Erection of 2 No. live-work units; change of use of existing student accommodation including internal alterations to form 2 No. dwellings, 2 No. new windows, new staircase & replacement of roof on outbuilding; reconfiguration of existing dwellings, replace existing timbers & roof joists on first floor; change of use from medical centre/offices to 2 No. flats & workshop. creation of new private gardens, separation of this part of the site from the wider University campus, creation of a shared landscaped courtyard, creation of areas for parking & storage for bins & cycles. This application affects the character & appearance of the Upper Bognor Road & Mead Lane Conservation Area.

65 Upper Bognor Road (Charlotte House 71 & 71A Upper Bognor Road, 67 & 69 Upper Bognor Road Bognor Regis

Thank you for your internet representation made on 13th March 2020 which has been recorded as '**an objection**' with the comments as follows:

Drawing
New Live Work Units
First Floor Plan Proposed

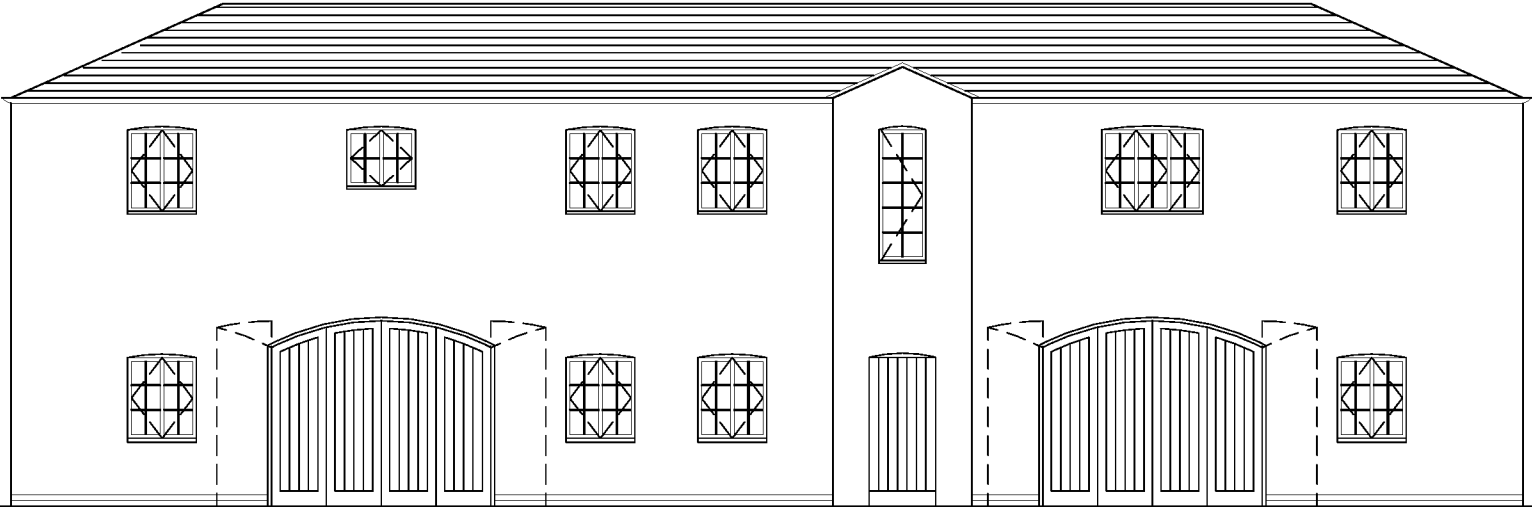
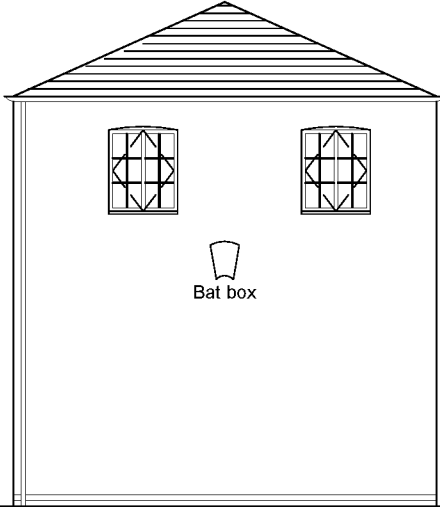
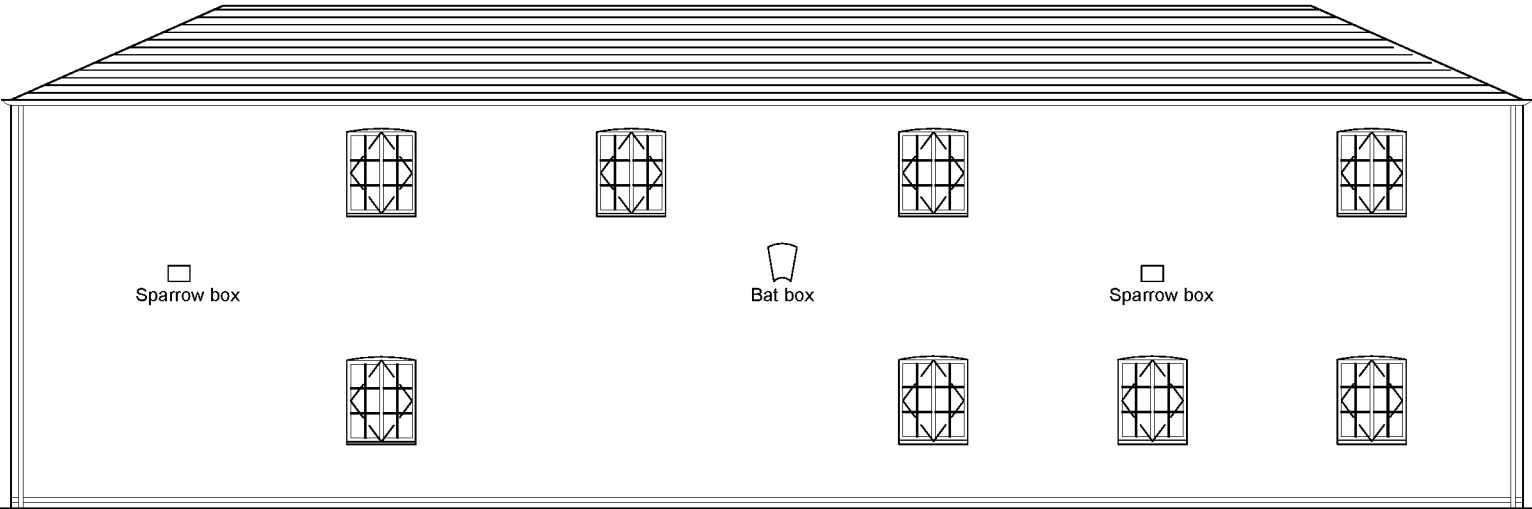
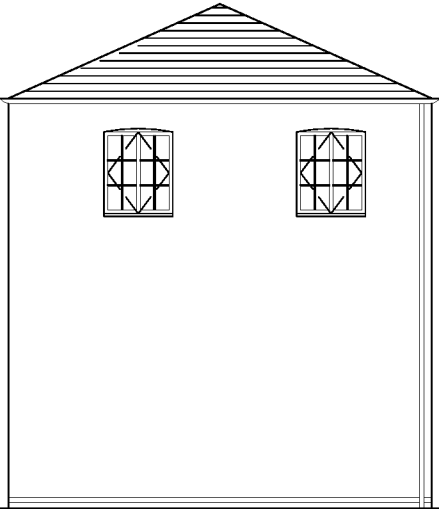
The panel welcome the conversion of the existing buildings and the design approach taken. Precise details of materials, finishes and new joinery need to be agreed with the LPA. However, our objection is based on the poor design quality of the new building. There is an odd window to wall ratio and the incongruous appearance of the lobby and staircase area. In addition there needs to be greater over style and depth to the eaves.
